Response to Agency Submissions

Staged Redevelopment of Greenwich Hospital

24 September 2019 | 2190376

DATE: AUGUST 2019	DRAWN: JC, MK	PROJ ARCH: BF	SCALE: 1:500 @ A1
	PROJ: 1213	DRAWING: IN.02	REVISION: P2

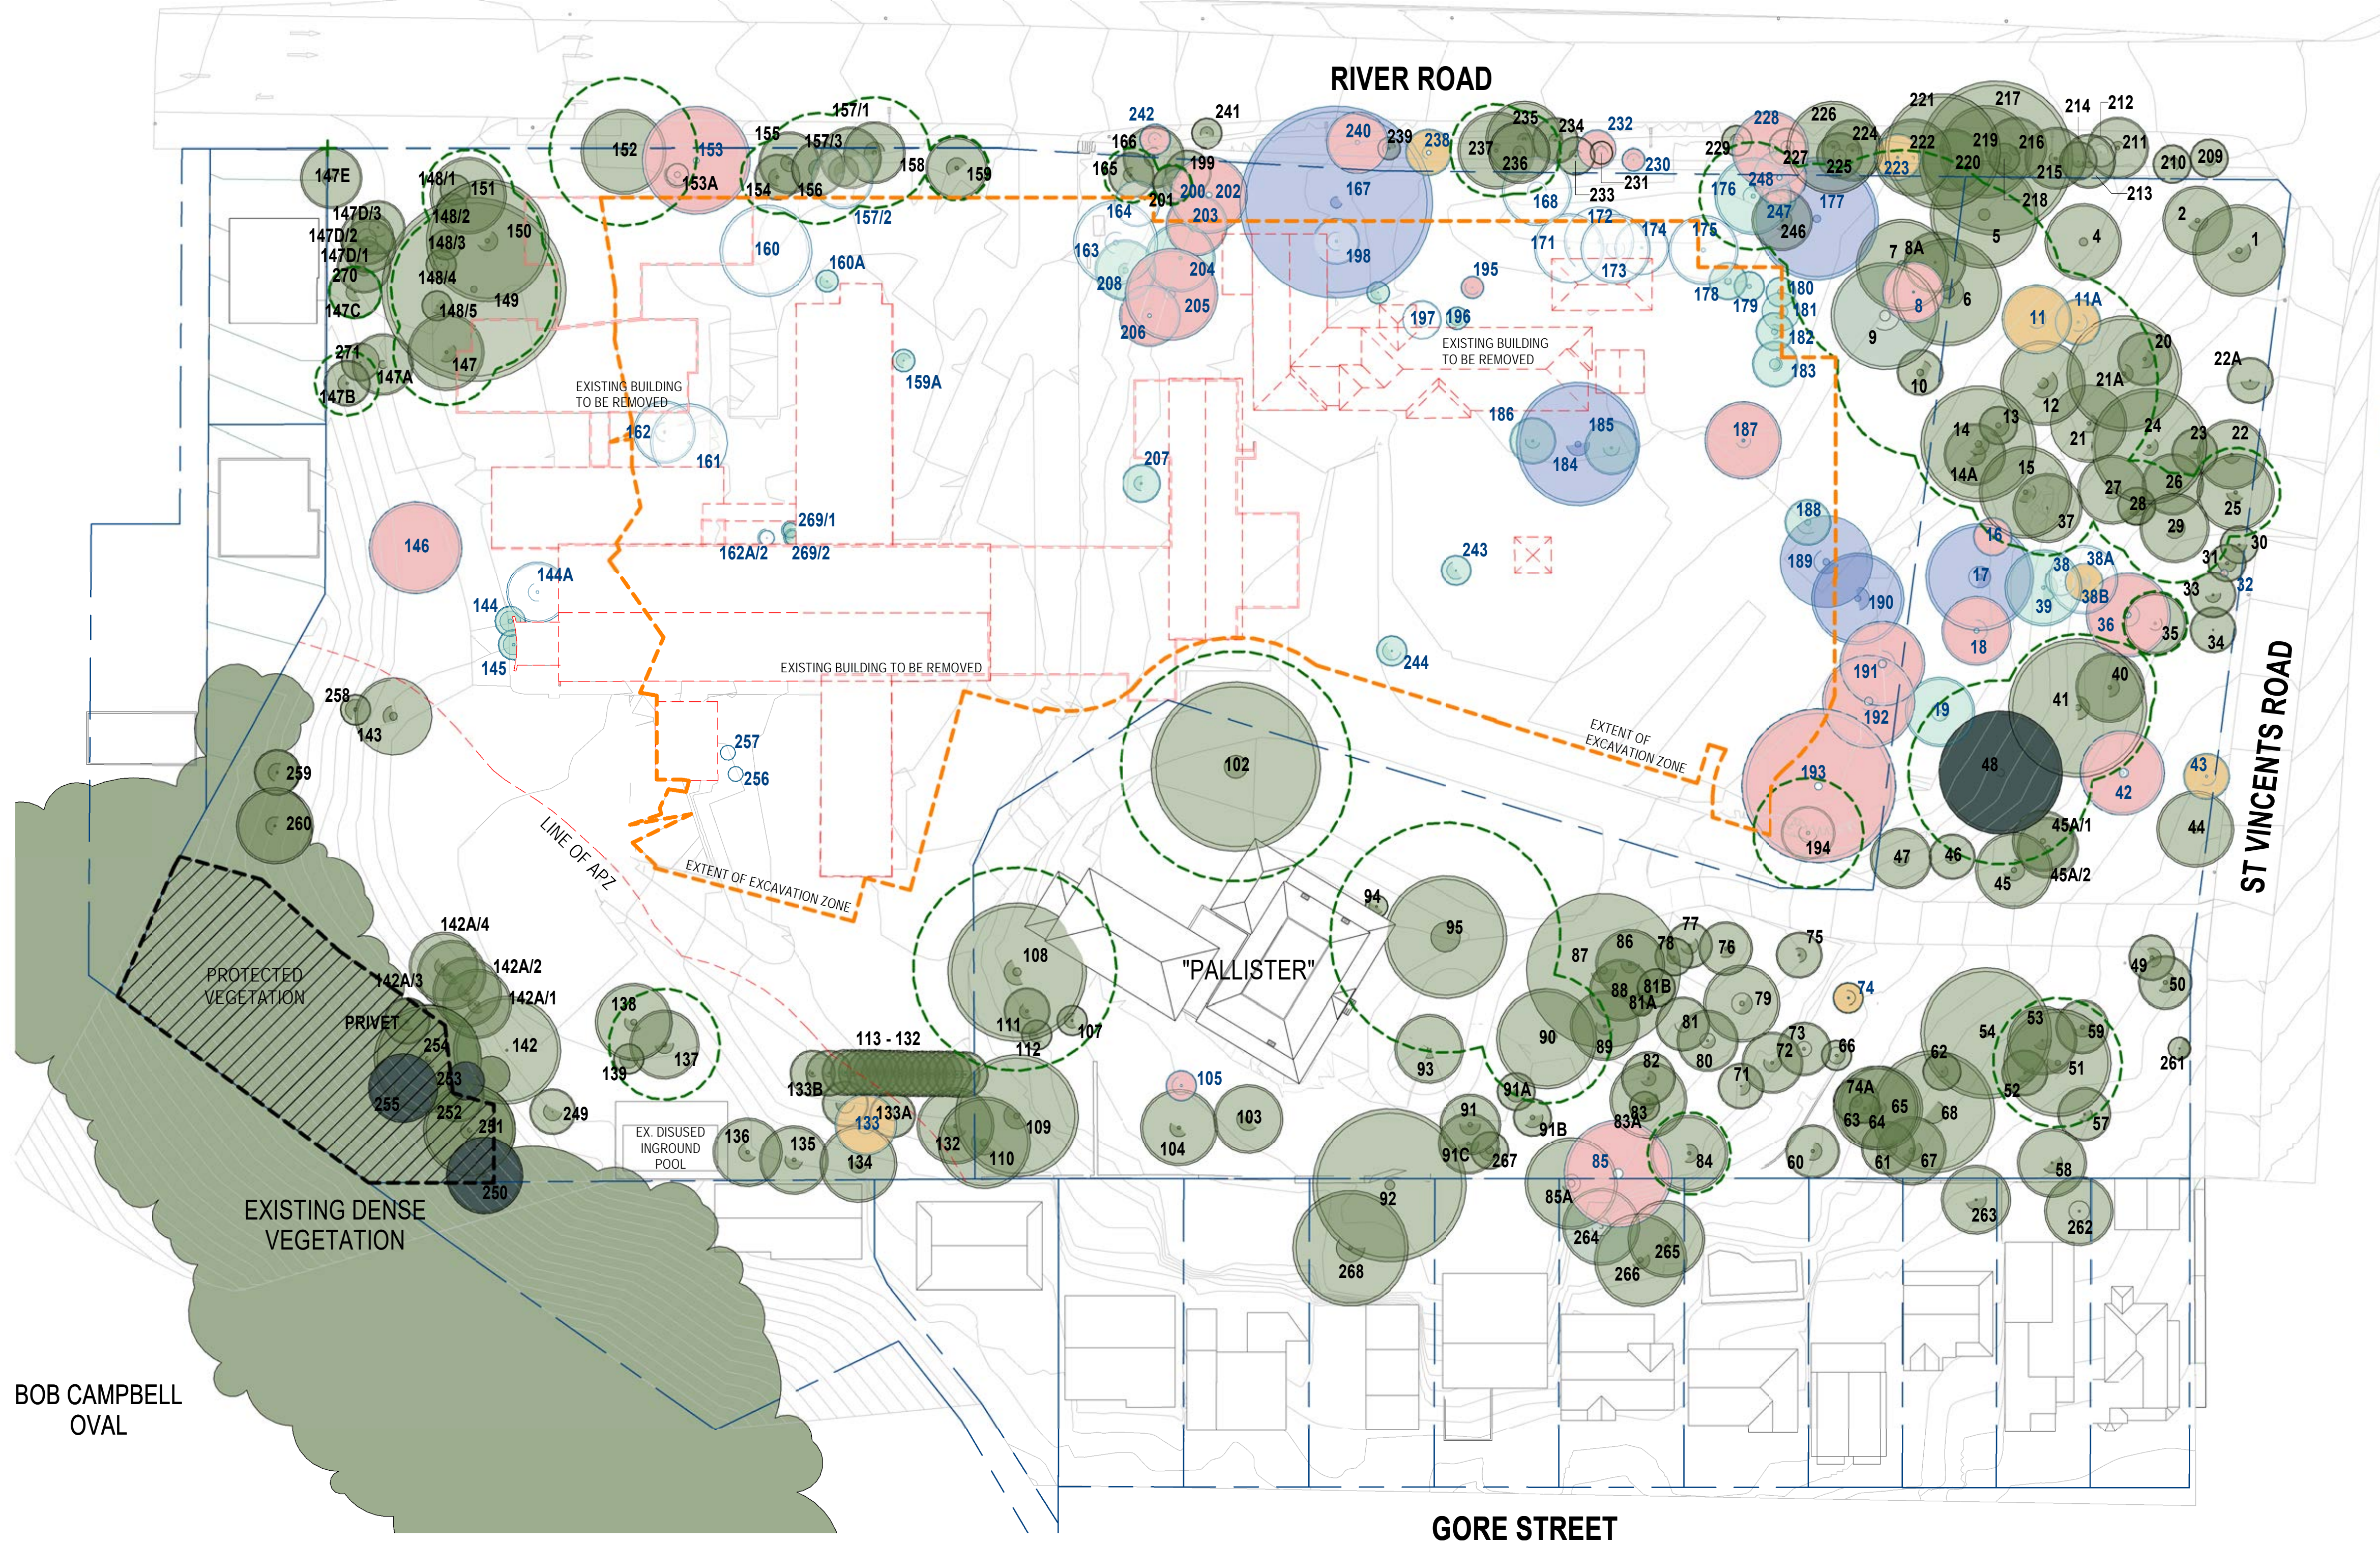
<p>Arborist Report / Biodiversity Report There are 235 individual trees located on and adjoining the site. A total of 131 of these have been proposed to be removed to facilitate the proposal, the remaining 104 have been proposed to be retained and protected for the life of the development. The report has not specified which trees of the 104 retained would be subject to minor or major encroachments (expressed as a percentage, low being equal to or less than 10% of the total Tree Protection Zone area). As a result, the level of construction impacts the retained trees would be subject to is unknown, rendering their potential for retention in question.</p>	<p>The amended proposal seeks to maximise the retention of existing trees and revised arborist and biodiversity reports have been prepared based on the amended proposal. Refer to Section 2.6 and 2.7 of the RTS Report for further information.</p>

<p>It is noted that a number of Blackbutt trees identified to be retained require further investigation including resistograph testing. Depending on the results of these investigations, it is likely that 131 is an underestimation of the number of trees that will be removed.</p>	<p>A revised Tree Survey has been undertaken and Arborist Report prepared for the proposal. These documents clarify the number of trees located at the site and within its immediate surrounds. Refer to Section 2.2 and 2.6 of the RTS Report for further information.</p>
<p>The report does not contain scaled site plans that identify the radius of Tree Protection Zones (TPZ) or Structural Root Zones (SRZ) in relation to the proposed development. Given the volume of trees assessed in this report it is</p>	<p>A revised Arborist Report has been prepared which includes the radius of Tree Protection Zones. Refer to Appendix G.</p>

Issue	Response
<p>considered scaled site plans that overlay tree data (TPZ, SRZ and canopy spread) onto the proposed plans are essential in the accurate assessment of the development. In light of the above, the arboricultural documentation provided is considered insufficient and inadequate.</p>	
<p>Bushland Adjoining Site The site is classified as Land adjacent to Bushland under the State Environmental Planning Policy 19 Bushland in Urban Areas. The southwest corner of the site adjoins a public reserve related to Gore Creek. The proposal is subject to an assessment against Lane Cove DCP Part H Bushland Protection. As per the DCP, the proposal should allow for a minimum 10m setback of all building structures from bushland to ensure the development does not impact on the integrity of the adjoining bushland. The proposal indicates an increase in shadows south west of the site at 9.00am during midwinter. The DCP recommends new buildings and structures to be designed and orientated to ensure reasonable sun access is maintained to adjoining bushland throughout the year.</p>	<p>It is noted that DCPs do not apply to State Significant Development, however a setback of at least 10m is provided to the bushland at the south eastern corner of the site and the development will not cause significant additional shadowing as the shadow of the proposed building envelope falls largely within the existing shadow caused by the site's steep topography and existing built form. Refer to Section 2.2 and 2.6 of the RTS Report for further information.</p>

DRAWING TITLE:
SENIORS LIVING - SOLAR ACCESS ANALYSIS
DIAGRAM
DATE:
AUGUST 2019
DRAWN:
CM
PROJ:
1213
PROJ ARCH:
BF
DRAWING:
IN.40
SCALE:
As indicated @ A1
REVISION:
P6

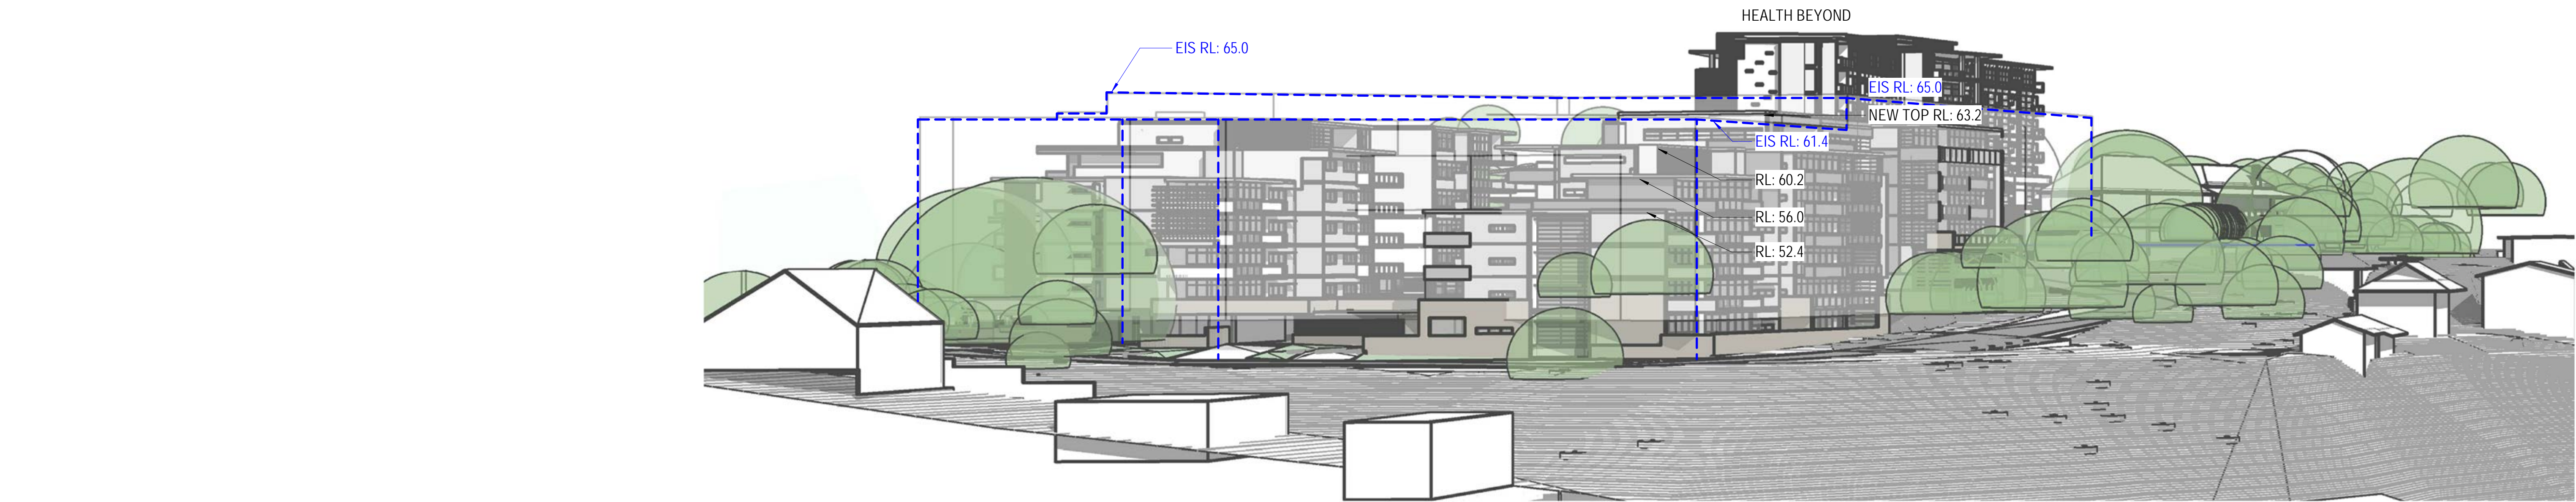
<p>The submitted shadow diagrams indicate the south and west elevations of both Senior living buildings receiving minimal solar access during mid-winter. 70% of all units should receive a minimum 2 hours of sunlight to living</p>	<p>Solar access diagrams have been prepared to demonstrate that the future detailed design of the seniors living buildings is capable of achieving 70%</p>

Issue	Response
rooms and private outdoor spaces between 9am and 3pm during mid-winter. The submitted shadow diagrams should be checked for accuracy. In particular, the contour lines at 24 Gore Street appear equally spaced on plan and should be reviewed.	solar access to all units. Refer to Section 2.8 of the RTS for further information.
<p>Traffic The applicant has provided a Traffic & Parking Impact Assessment prepared by Baker Ryan Stewart dated October 2018. Council supports the relocation of the majority of at-grade parking to basement level. This would allow increased landscaping in open space areas and increased amenity. Detailed basement carparking plans have not been provided for assessment. All off street parking is to comply with the relevant provisions of the SEPP and Part R of Councils DCP Traffic Transport and Parking.</p>	Noted, a detailed Traffic and Parking Assessment will be provided as part of a subsequent detailed design application.
